WEST SUSSEX COUNTY COUNCIL CONSULTATION

TO:	Arun District Council FAO: Anita Gardner
FROM:	WSCC - Highways Authority
DATE:	25 February 2020
LOCATION:	6 Manor Road Rustington BN16 3QT
SUBJECT:	R/268/19/PL Demolition of existing garage & store on existing dwelling & erection of 1 no. four-bed chalet style dwelling (re-submission of planning ref: R/72/19/PL). More information received.
DATE OF SITE VISIT:	n/a
RECOMMENDATION:	Advice
S106 CONTRIBUTION TOTAL:	n/a

Fig 4. Extract from Proposed Site Plan

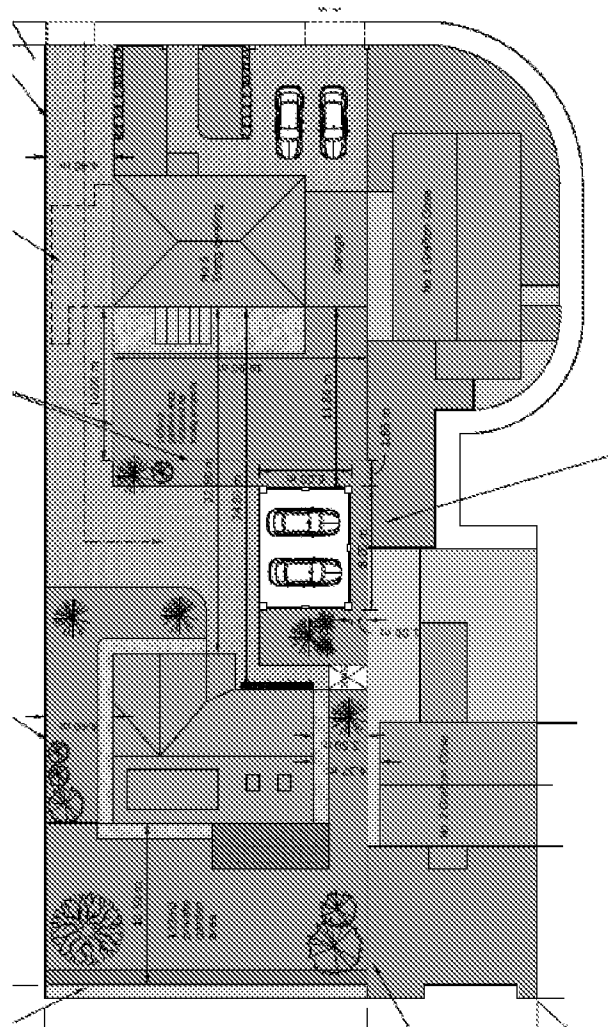
The applicant proposes to extend the hardstanding area within the existing dwelling's curtilage to accommodate the displacement of the western garage and drive way because of the proposed dwelling. The proposed hardstanding area is large enough to accommodate three parking spaces. The existing eastern garage will be retained providing an area of 4 x 7.6 metres; this can accommodate one car and include cycle parking.

The applicant will provide a garage (8 x 6 metres) large enough to accommodate a parking provision for two cars as per the Arun Parking Standards for a dwelling of this size and location.

The submitted plans show an area located to the southwest of the garage maybe used as a turning area. This area measures 6.6 x 6 metres. This is within Manual for Streets (MfS) recommendation of 6 metre depth for a turning area.

As per Plans titled *Proposed Site Plan – Revised Version* and dated 24/02/2020, cycle parking will be provided in the newly proposed two bay garage. This conforms to requirements set out by Manual for Streets (MfS) for covered, lockable storage.
